**WELWYN HATFIELD BOROUGH COUNCIL
DIRECTORATE OF STRATEGY AND DEVELOPMENT**

DELEGATED APPLICATION

Application No: 6/2016/1677/MAJ
Location: Blue Moon Paddock, Woodfield Lane, Brookmans Park
Proposal: Demolition of existing redundant structures and erection of single family dwelling house, together with associated tree planting scheme (part of Centenary Woods project sponsored by Woodland Trust); landscaping and car parking
Officer: Mr M Peacock

Recommendation: Refused

NORTH ELEVATION B

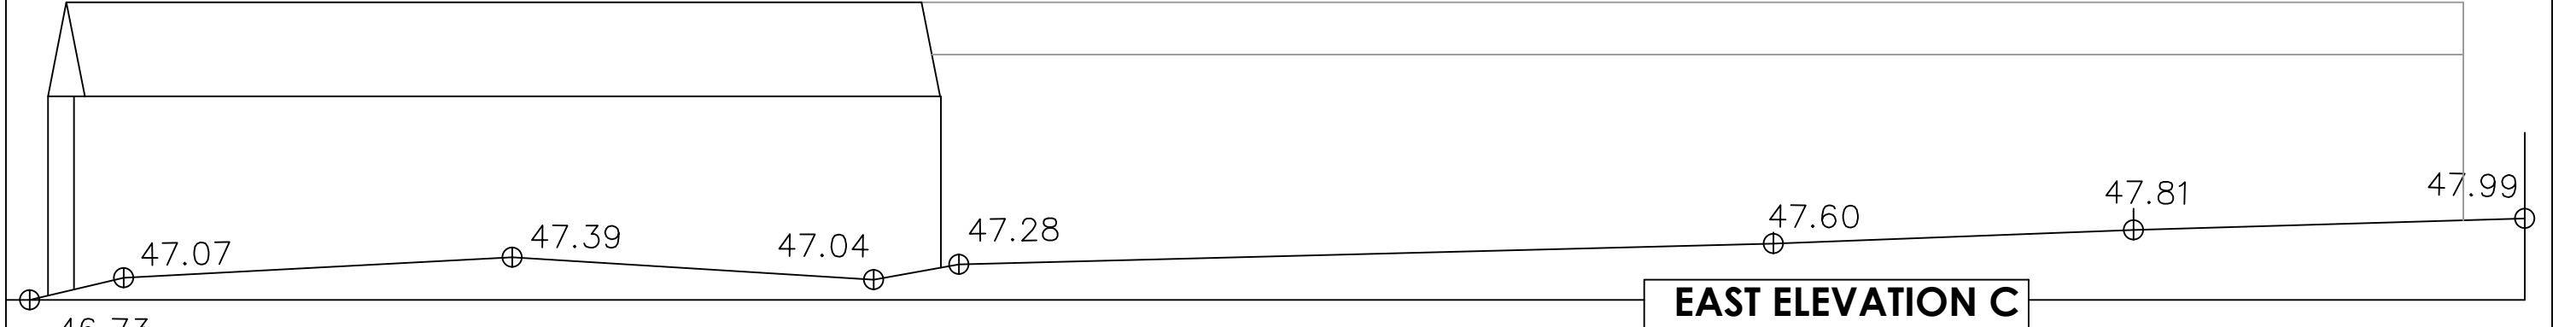
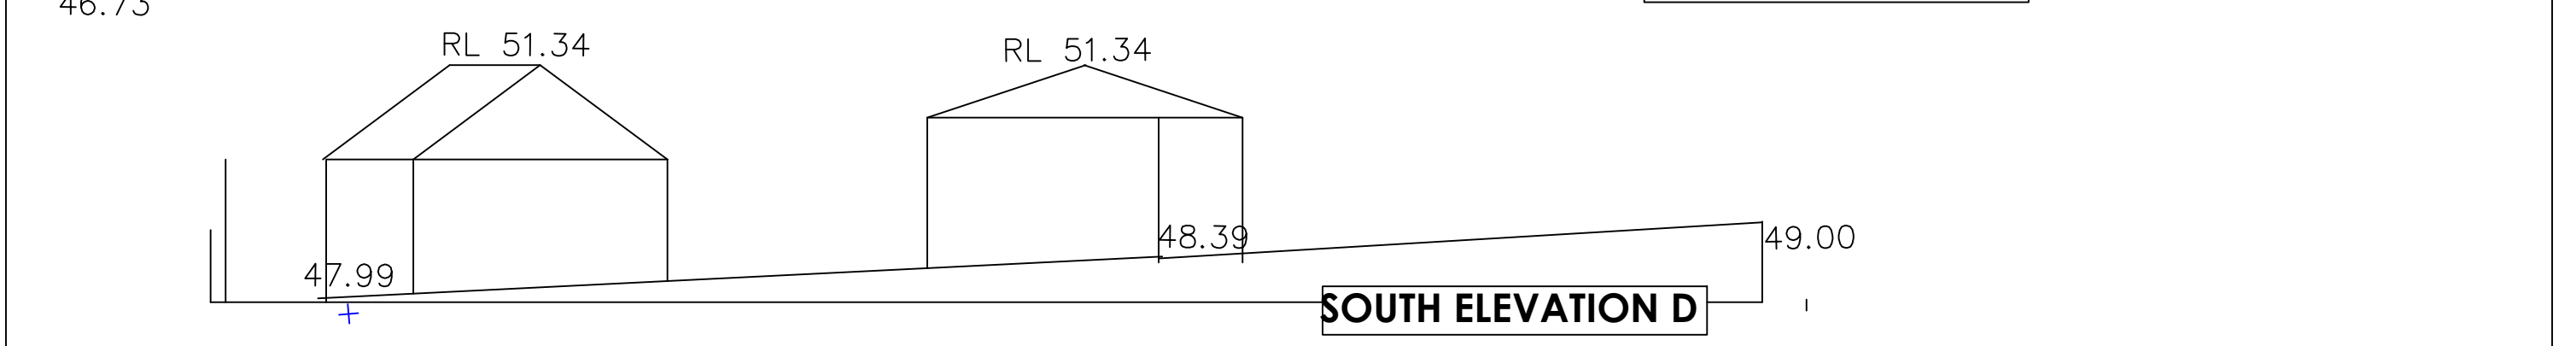
The submitted Sectional Drawing (P/310 A) shows the height of the existing barn and stable as 3.98m and 3.25m respectively (Elevation B). By comparison, the proposed new building would measure approximately 7.2m in height, which is an increase of 81% and 122% respectively.

The proposed building is demonstrably larger, taller and bulkier than the relatively modest structures that it would replace. The proposal would therefore introduce more built development and physical permanence than exists at present.

EAST ELEVATION

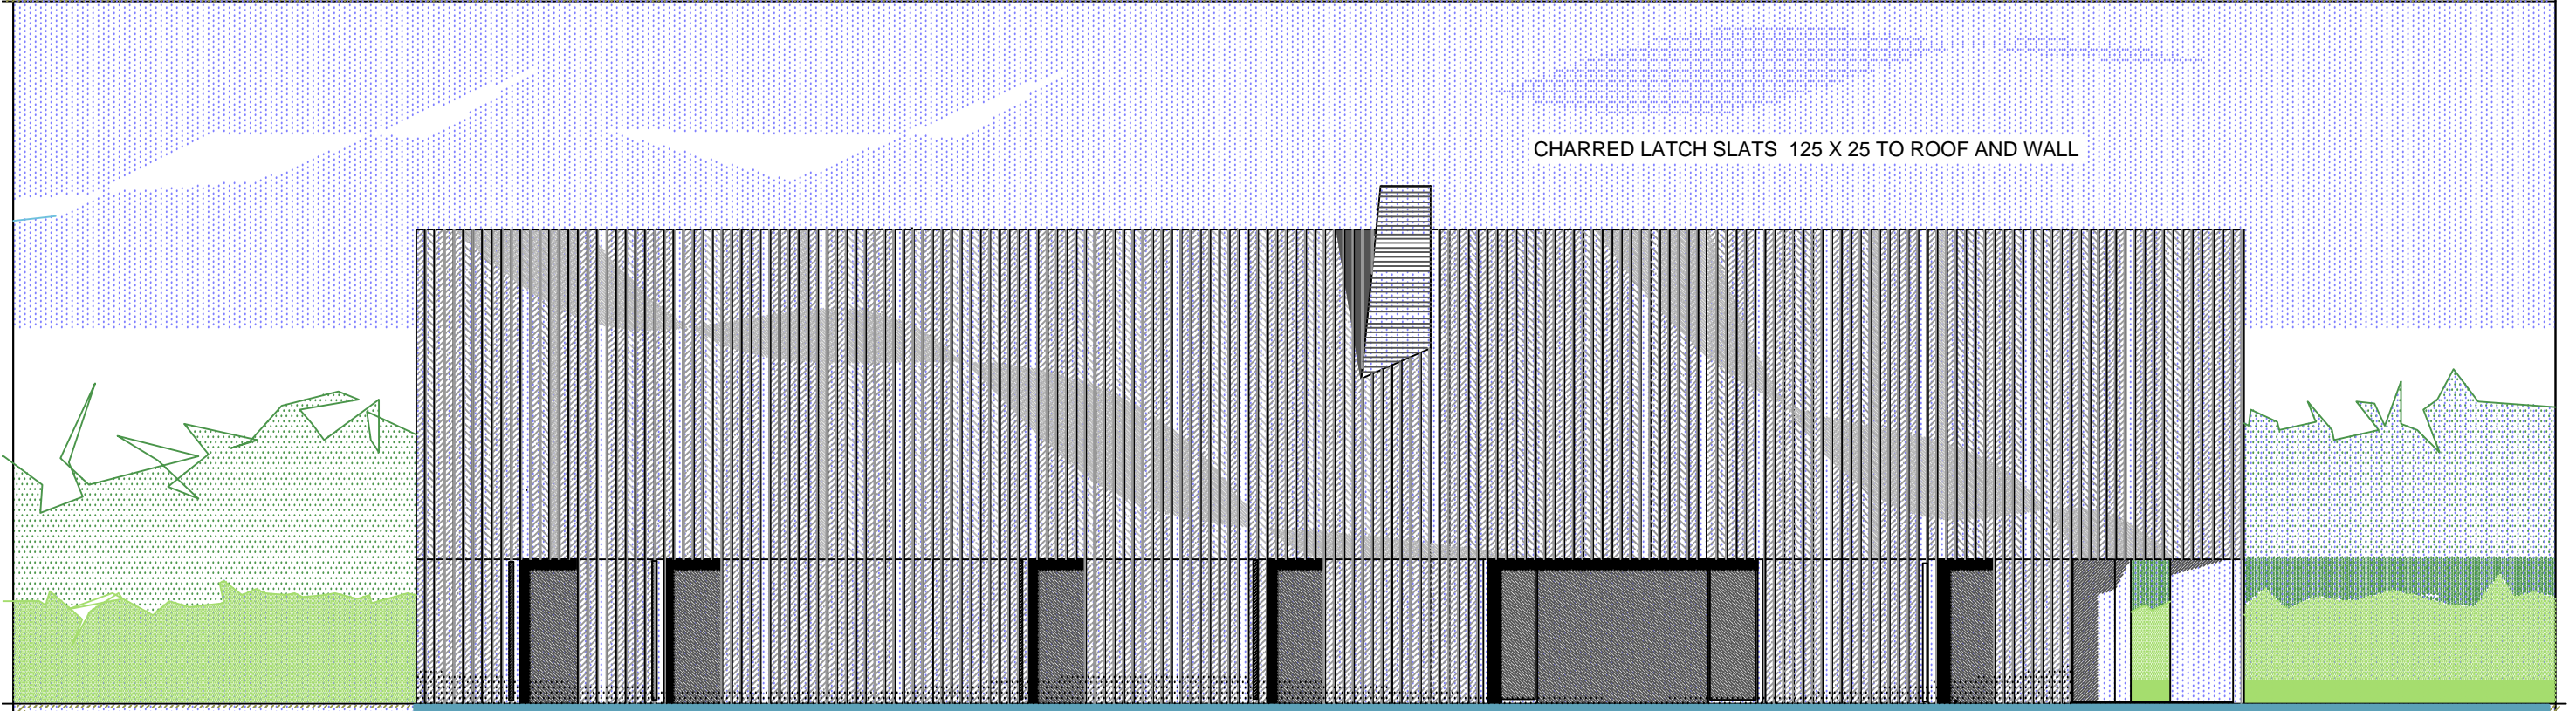
surroundings. This assessment is considered to be over-generous. Charred larch is, more or less, black in colour and would be conspicuous against the surrounding landscape and the skyline. Polished stainless steel is arguably more suited to an urban environment and, because of its unnatural and unsympathetic appearance, would jar with the rural character of the application site. Natural materials, sympathetic to the rural setting would be more appropriate, such as a natural timber that can weather in harmony with the surrounding woodland.
